DECISION DELEGATED TO DEVELOPMENT MANAGER

Application No: H02-0857-19 **Applicant:** Mr & Mrs M Woodcock

Proposal: Two-storey side extension with annexe, single-storey rear extension and roof conversion (re-submission of H02-1163-18)

Location: 15 Kemp Street Crowland Spalding

PROPOSED GROUND FLOOR PLAN 1:50

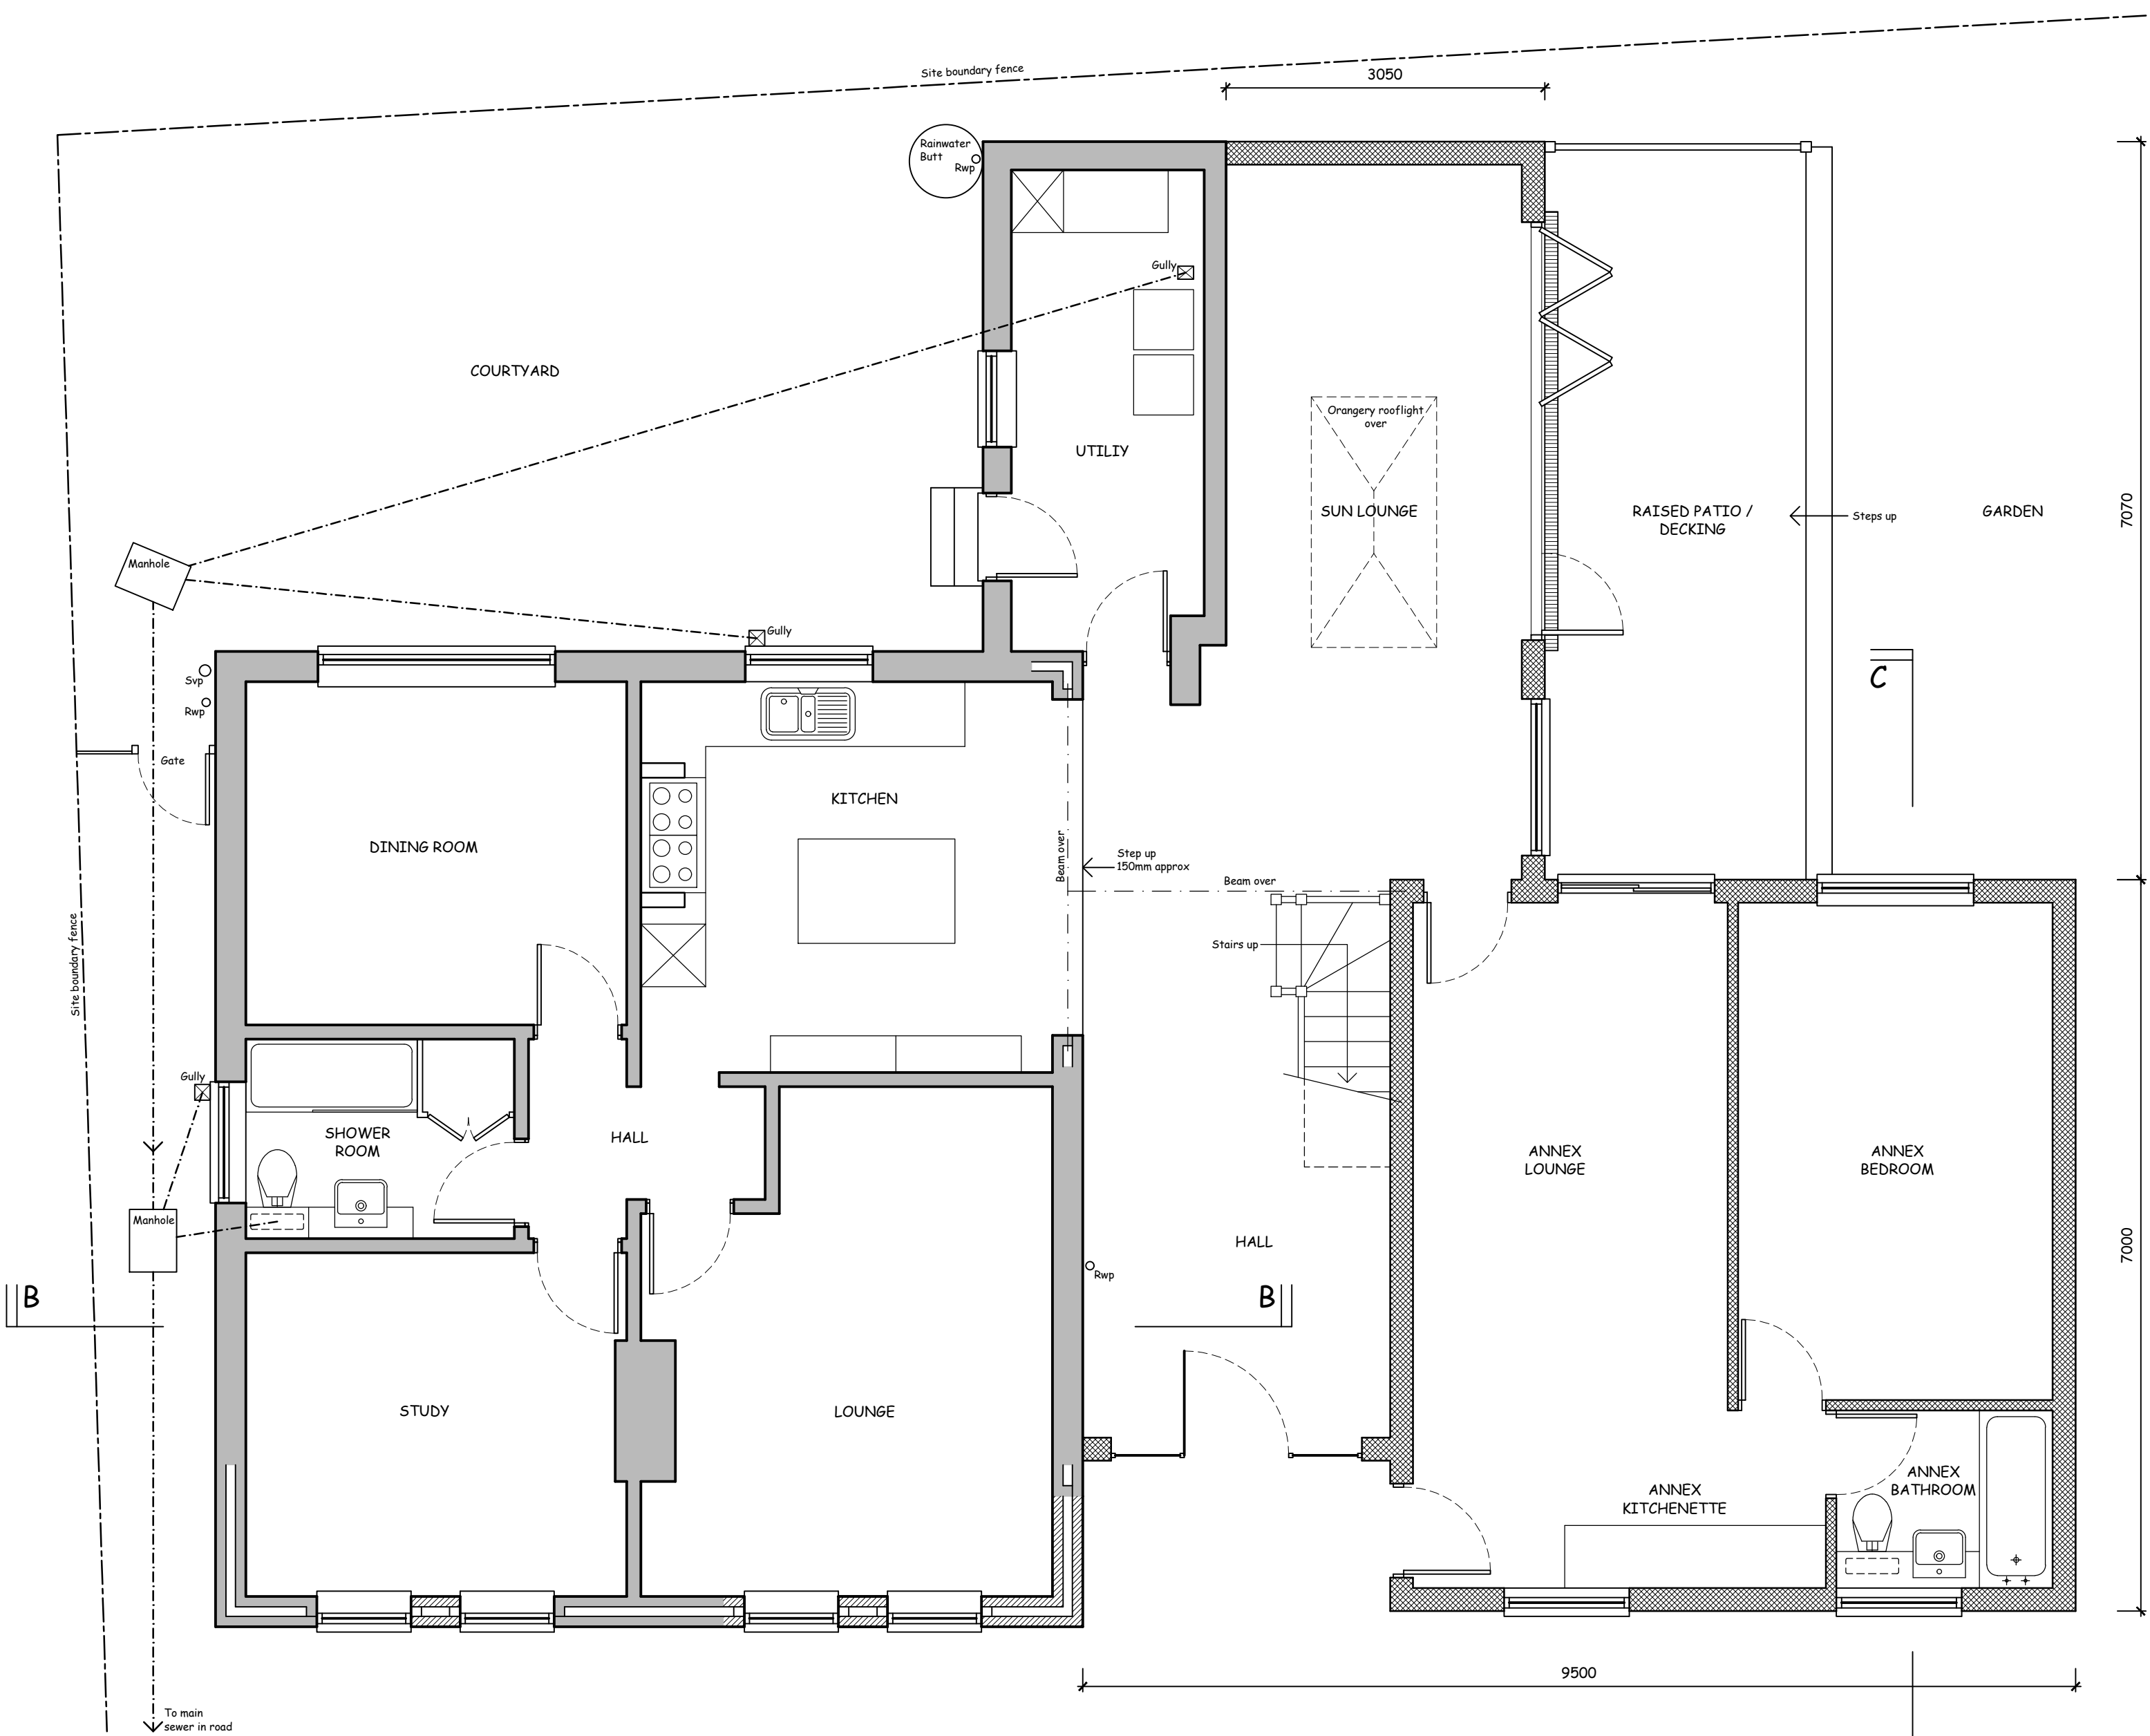
The proposed alterations are the replacement of garage doors to windows and a reconfiguration of the ground floor plans. Instead of one large room for the double garage, it will be an annexe lounge, kitchenette, bedroom and a bathroom, which fits appropriately in the same footprint. Therefore, the layout and design of this application would be acceptable and not have an adverse impact upon the character and appearance of the surrounding area.

PROPOSED FRONT (SOUTH) ELEVATION 1:100

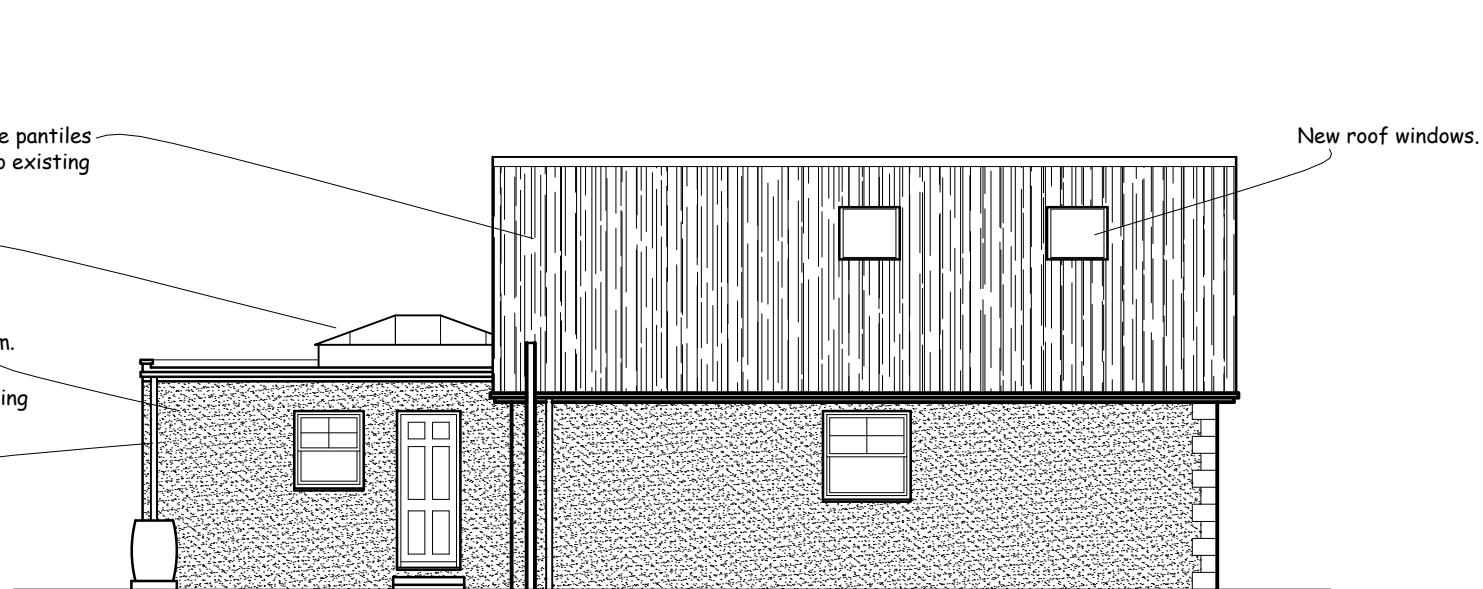
The re-submission shows that there will be 2 new windows to the front of the property in replacement of the garage doors. This would not have an overlooking impact as the property opposite (No. 20) will not directly overlook due to the high boundary treatment, approx. 1.8m, and the windows being at an angle. In addition, there are already existing windows to the front of the property.
